R/194/25/HH

Subject: FW: R/194/25/HH

First Floor Plan
Proposed
1:50

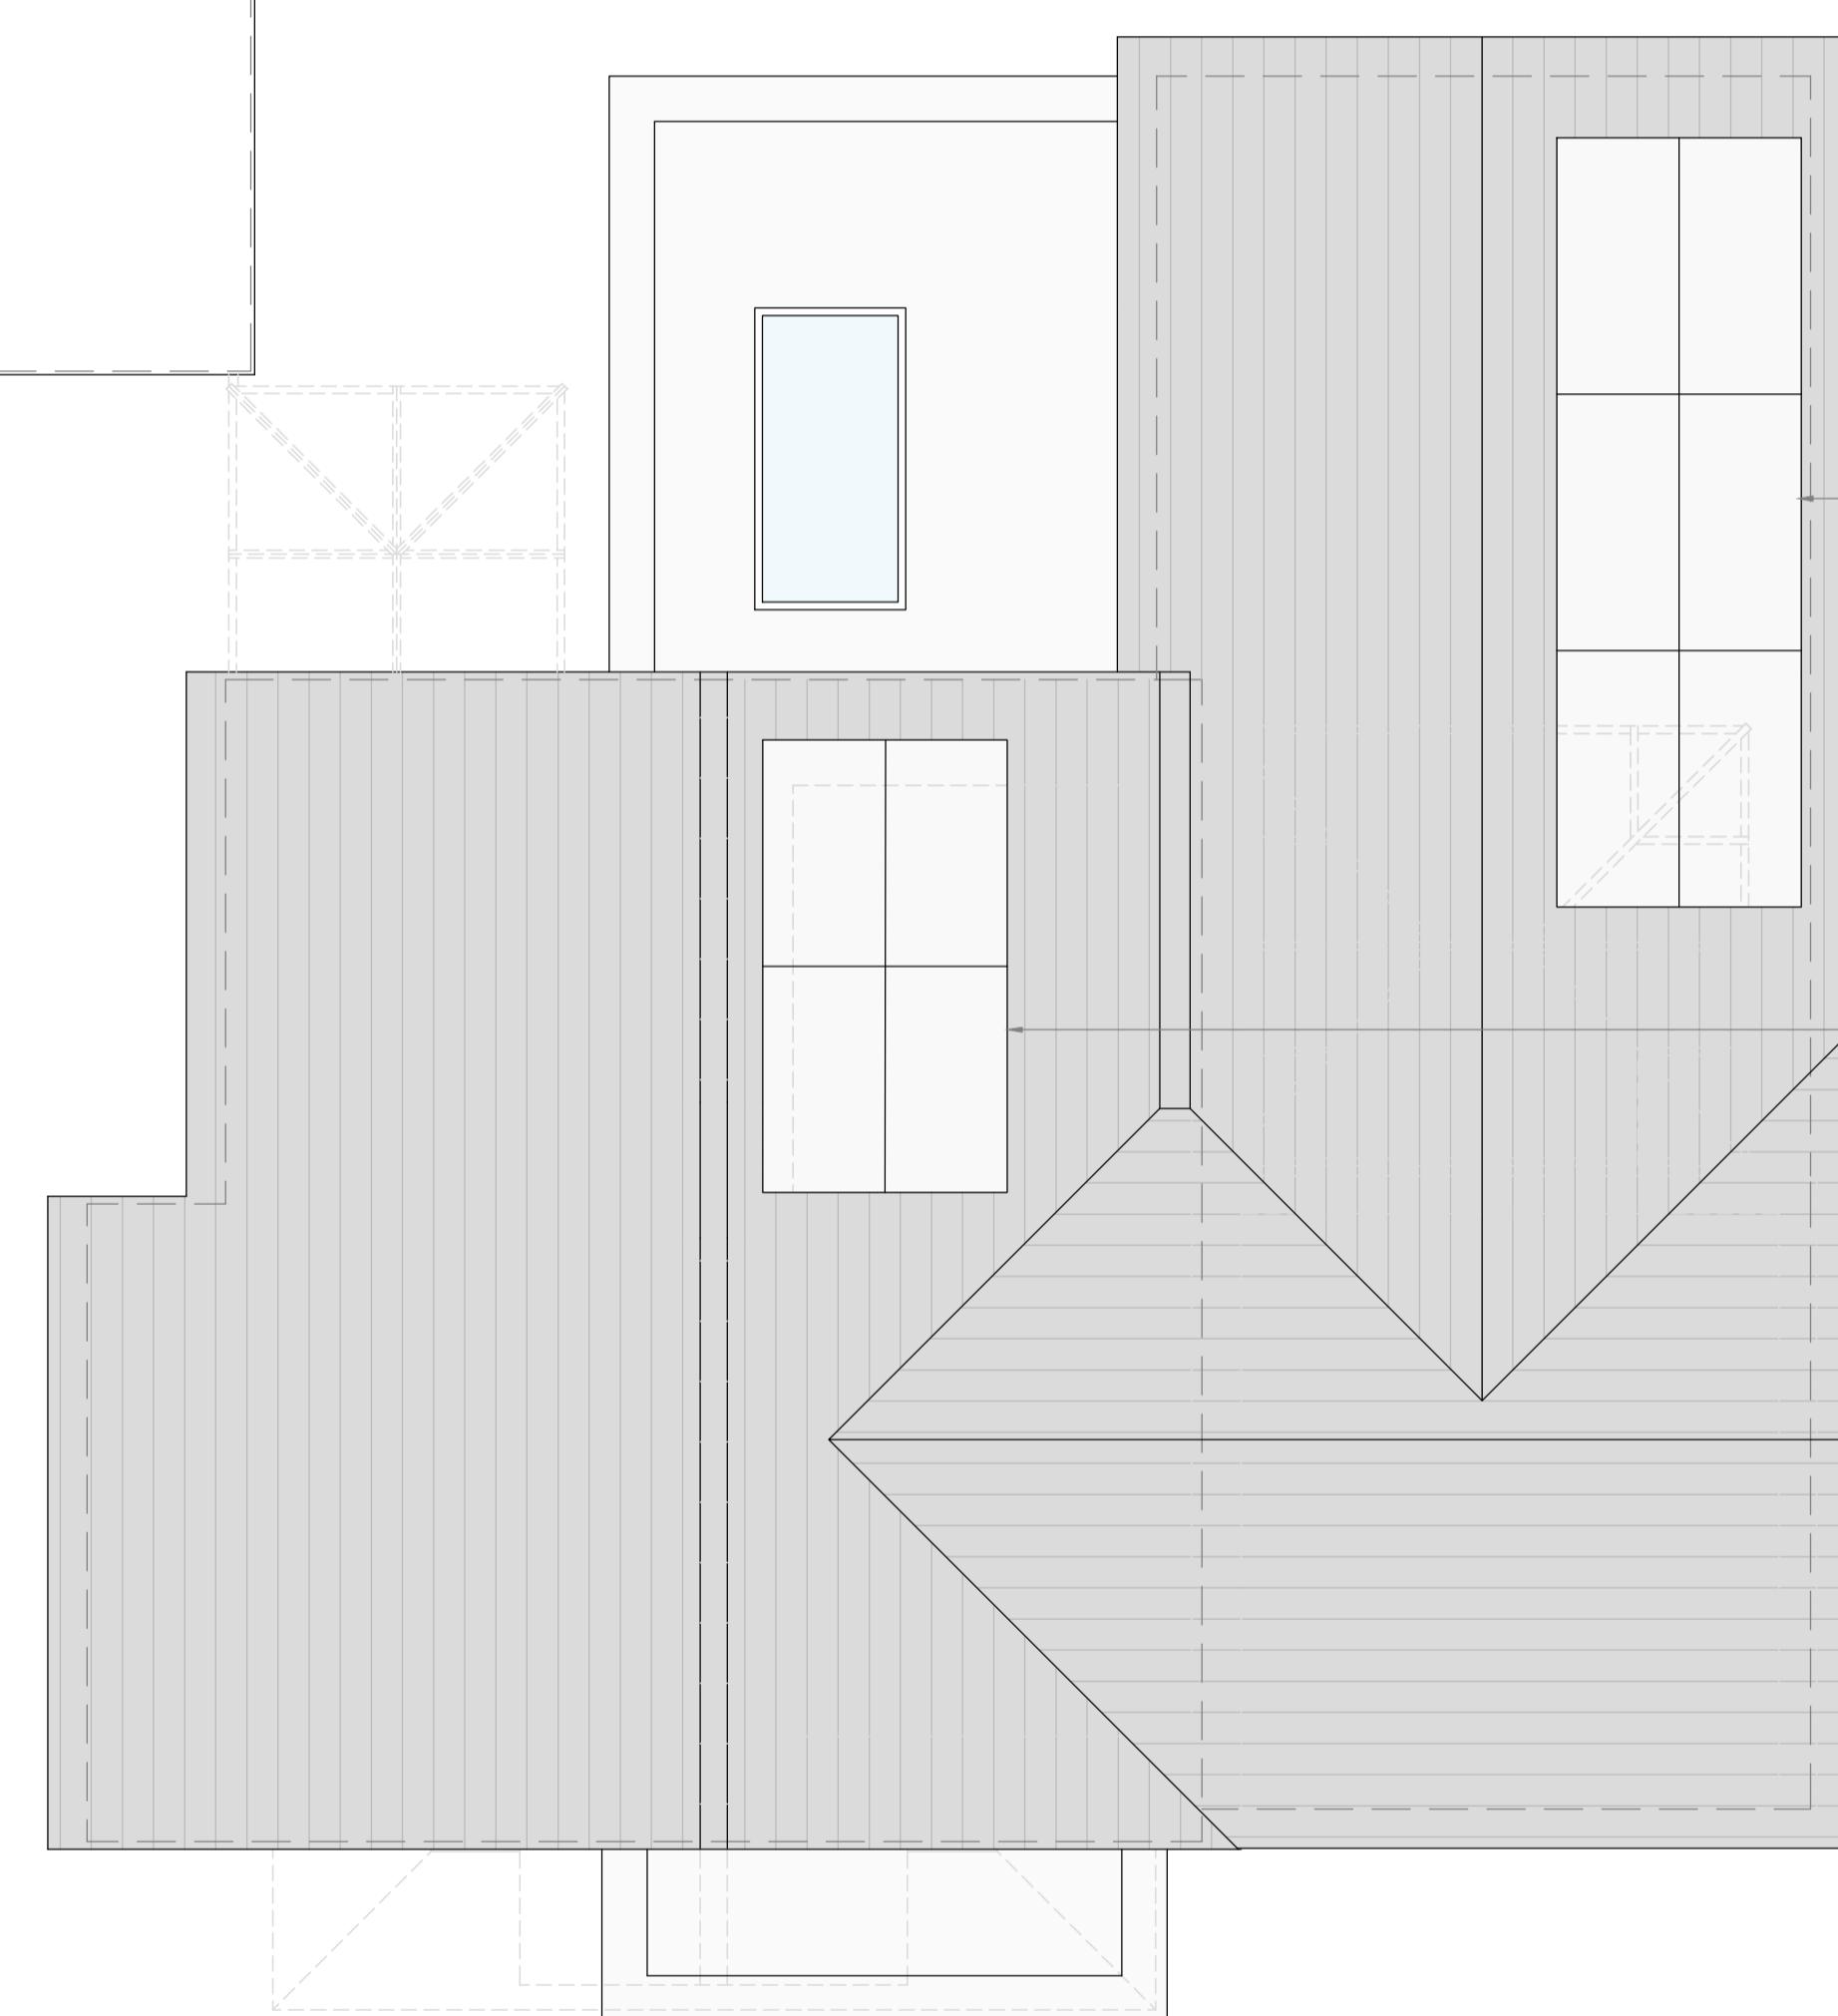
The proposed extension replaces them with a new triple and double window. In addition there is a feature, wide picture window of additional height, together with a Juliet balcony, serving the main bedroom, considerably closer to our boundary than the previous elevation, as a result of the new build area extending significantly further out into the rear garden.

East Elevation (Rear)  
1:100

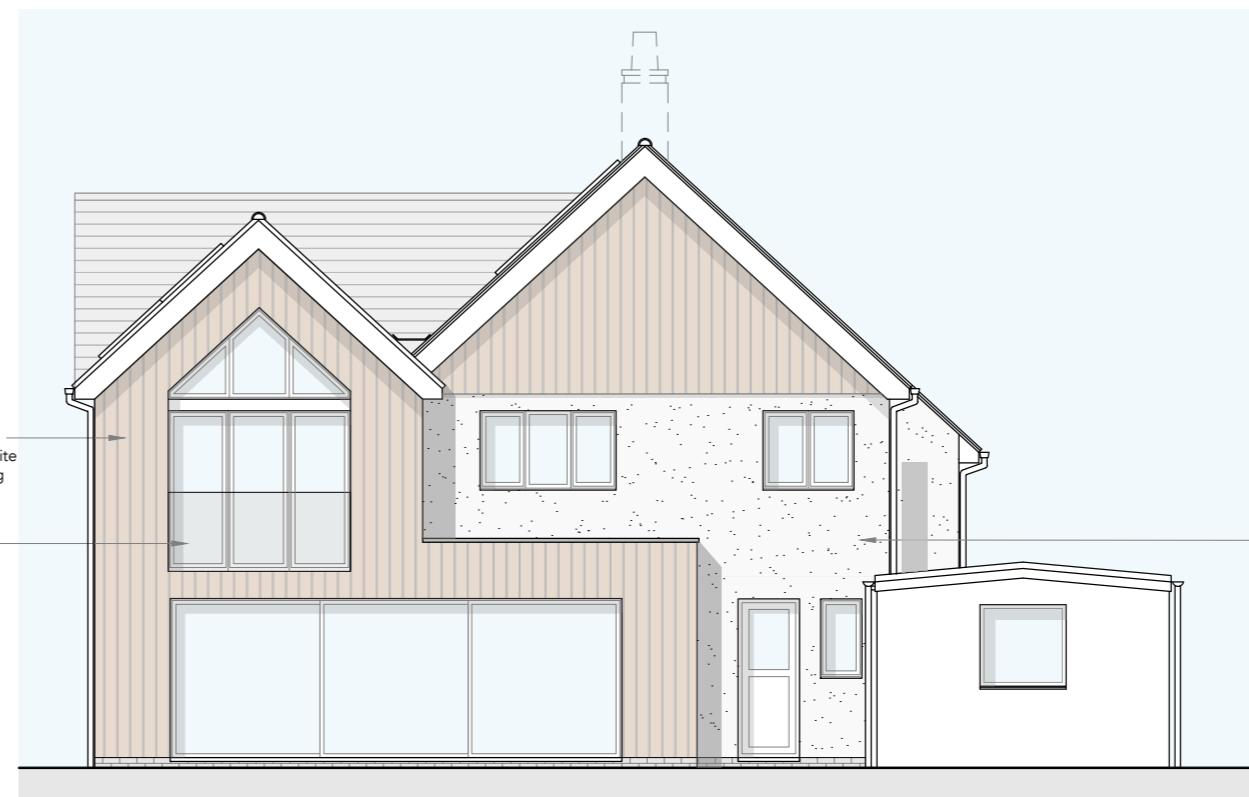
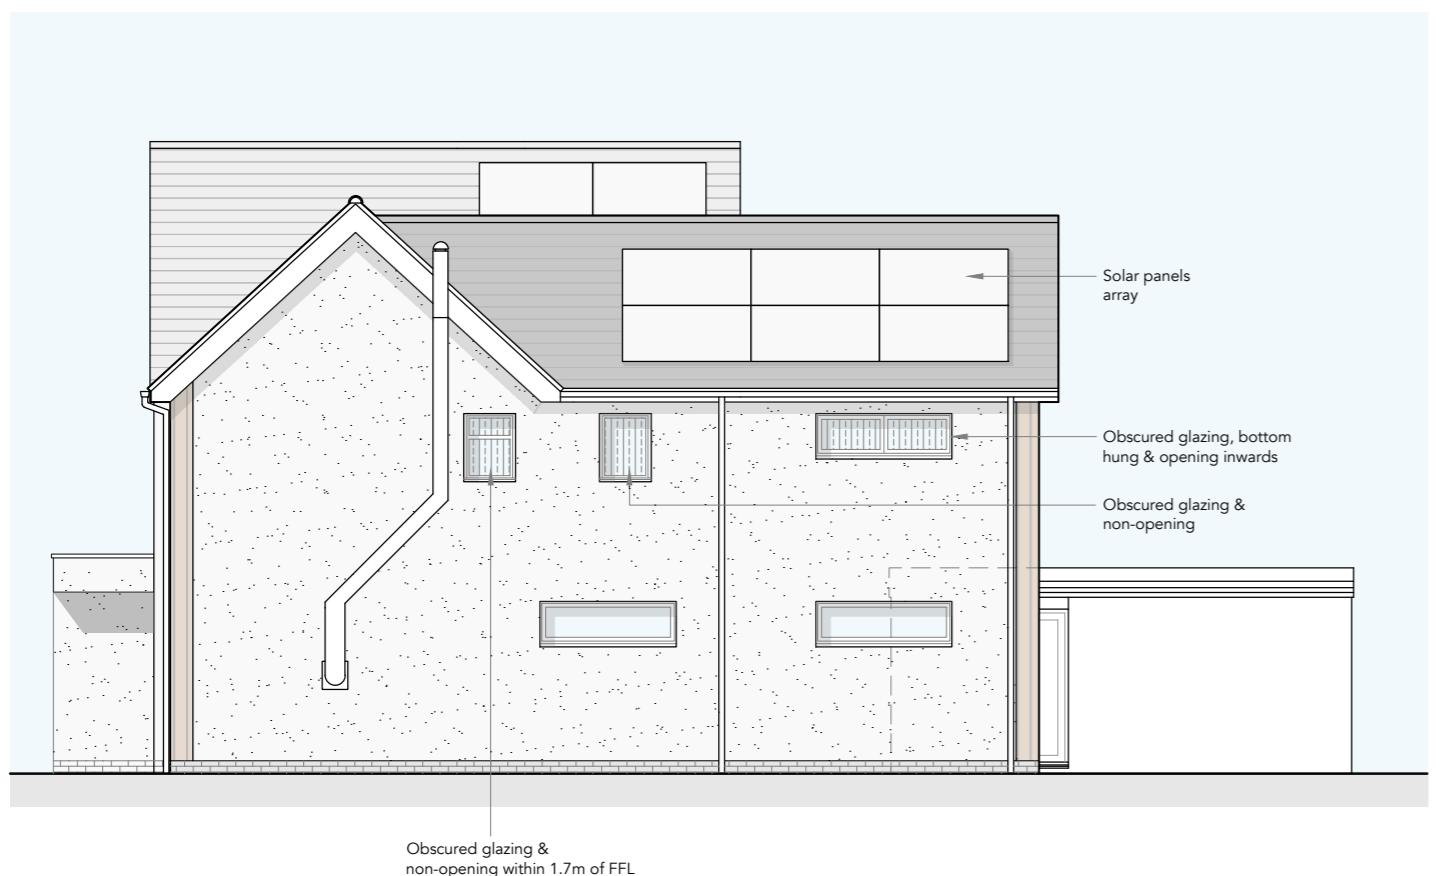
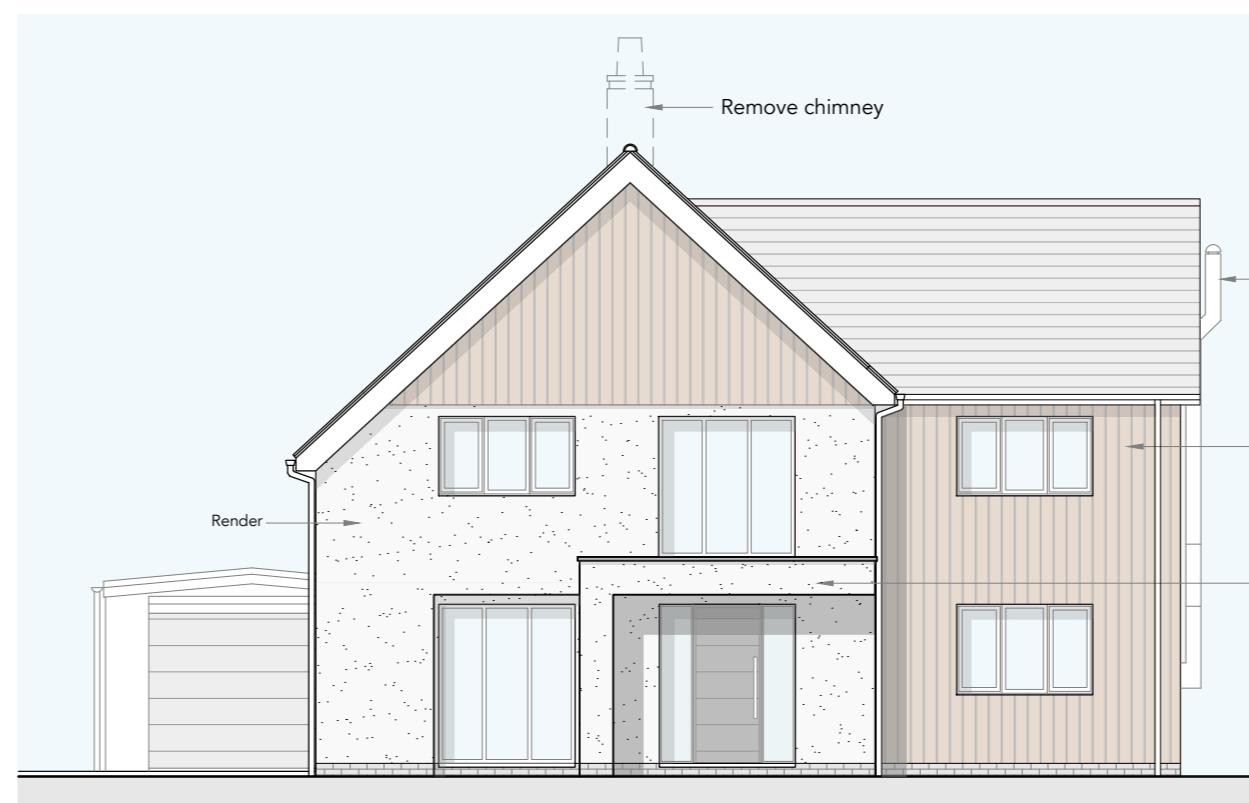
At present the rear elevation of 19 The Parkway, offers three single windows at first floor level. These overlook our garden, at 18 Sea Avenue, and have sight into the kitchen, lounge and main bedroom of our house. Being limited in size and function, we have had no issue with them.

We have enjoyed very good relations with the previous owners of this property and obviously would wish this to continue, but we must ask whether there can be some mitigation for what clearly would be a much greater extent of overlooking.
